RE: Spring Tree Ranch Rezone (RZ-24-00002 / CP-24-00002)
Applicant: Pat Deneen
Applicant: Spring Tree Ranch LLC (Owner)

The following signed property owners surrounding this proposed redevelopment of Spring Tree Ranch LLC are submitting this request for Kittitas County Development Services to **DENY** the application as written and proposed due to numerous issues that have not been addressed in the preliminary application. If more information is provided for issues below, we still believe approval will harm the peace, repose and use of our respective properties surrounding the redevelopment area and negatively affect our properties and their respective values.

REVISED SPRINGTREE RANCH MASTER PLAN - SITE PLAN

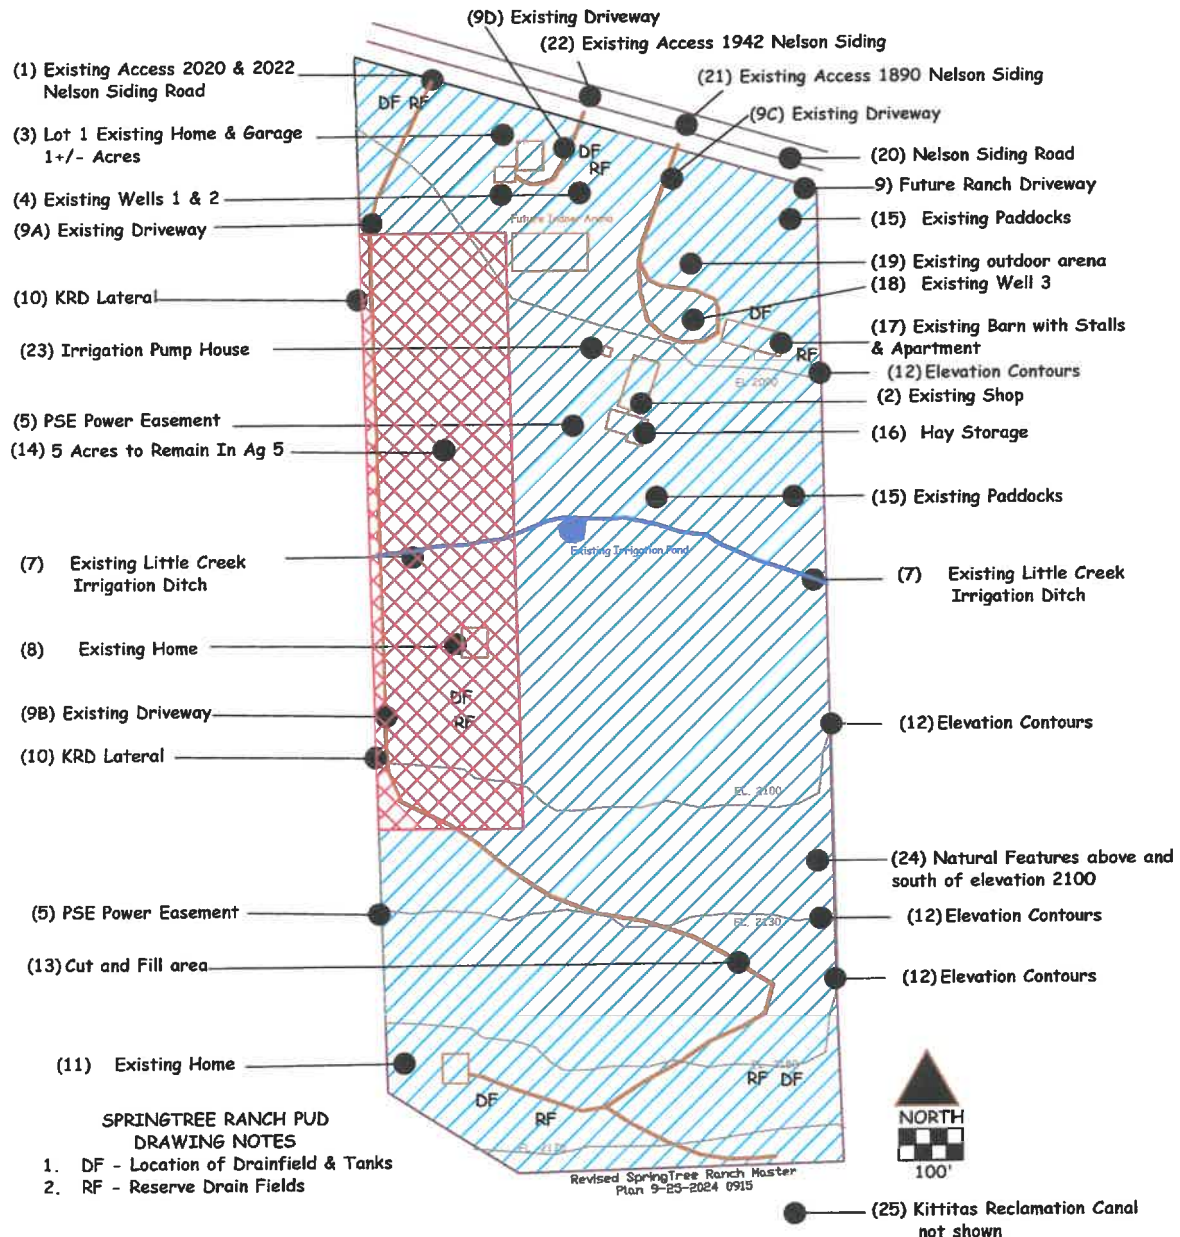
- The proposed indoor arena, according to the map, is directly adjacent to the property lines of parcel 13632 (2144 Nelson Siding Rd) and parcel 13630. What is the proposed set-back from any indoor riding arena from the parcel line? What is the expected noise (DB) increase from this proposed riding arena that will affect these lots and what methods of mitigation are proposed?

- Parcel 13632 (2144 Nelson Siding Rd) has a KRD lateral that runs the parcel line between the proposed development and the proposed indoor riding arena. There is also the Little Creek irrigation ditch that runs immediately adjacent to the proposed riding arena. What protections will the proposed development use for this open lateral and open trench irrigation ditch due to the expectations that parking, horses and others will be around this open water source?

- The map and proposal intends to make one large lot of 27.27 acres. Should we be expecting another proposal to subdivide in the future to sell off these homes?
